Epping to Thornleigh Third Track Proposal. Application number SSI 5132.

/We object to the Epping to Thornleigh Third Track Proposal and consider that the EIS is inadequate and does not address the full impact of this proposal. It will cause untold damage to the health of residents and to the fabric of the Beecroft Cheltenham Heritage Conservation Area. Do not approve this project, reconsider the alternatives and protect the community.

Figure 5.6 Cross-section and elevation - New Cheltenham Station concourse building
Note: Indicatively added to future design

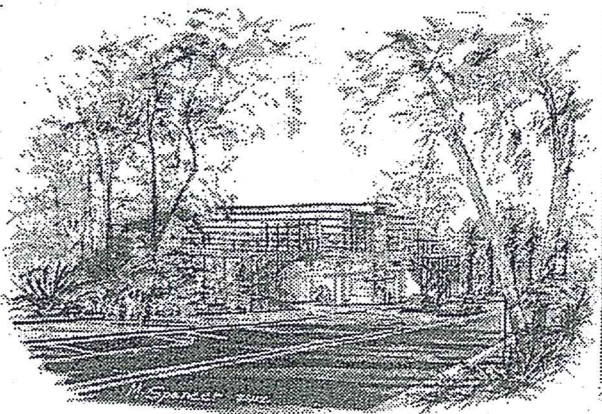
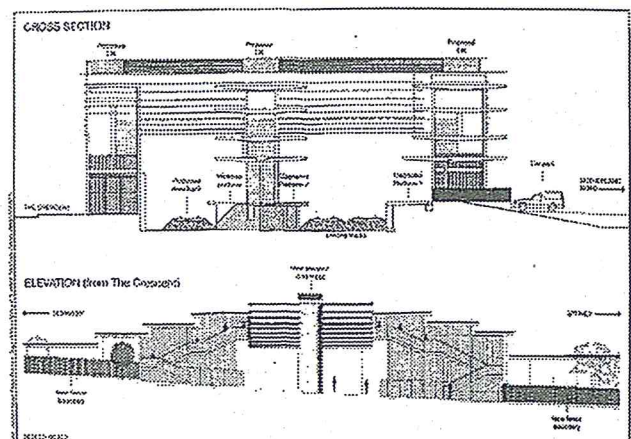
- The proposed redevelopment of Cheltenham Station shows no regard for the HCA. The visual impact of the proposed 13m high glass and steel concourse is totally unacceptable in this HCA.

Concept design drawing of proposed changes to Beecroft Station (Parsons Brinckerhoff 9/3/12). Former side platform shaded in pink.

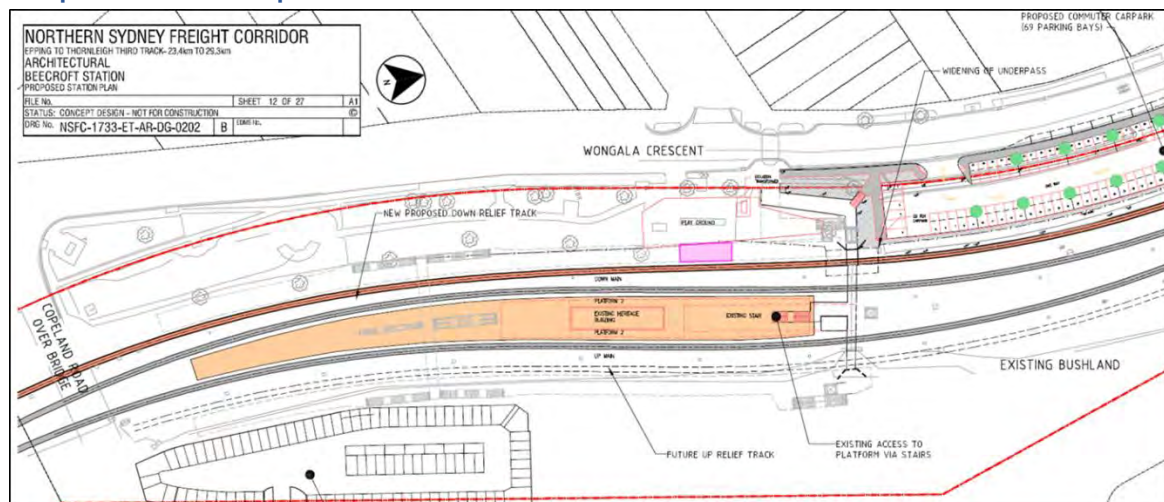
- There has been inadequate assessment of the project's impact on the fabric of the Beecroft Cheltenham Heritage Conservation Area (HCA).
- The plan given for Beecroft Railway station Precinct is vague. The relationship to the trees, playground and original 1895 platform located south of the present station is not shown. A fourth track is shown on the eastern side. The plan does not include urgently needed lifts to allow disabled access at Beecroft Station.

- Beecroft Station Gardens have a heritage listing with Hornsby Council but the impact on them has not been adequately addressed. No arborist's report is given for the trees which will be removed.
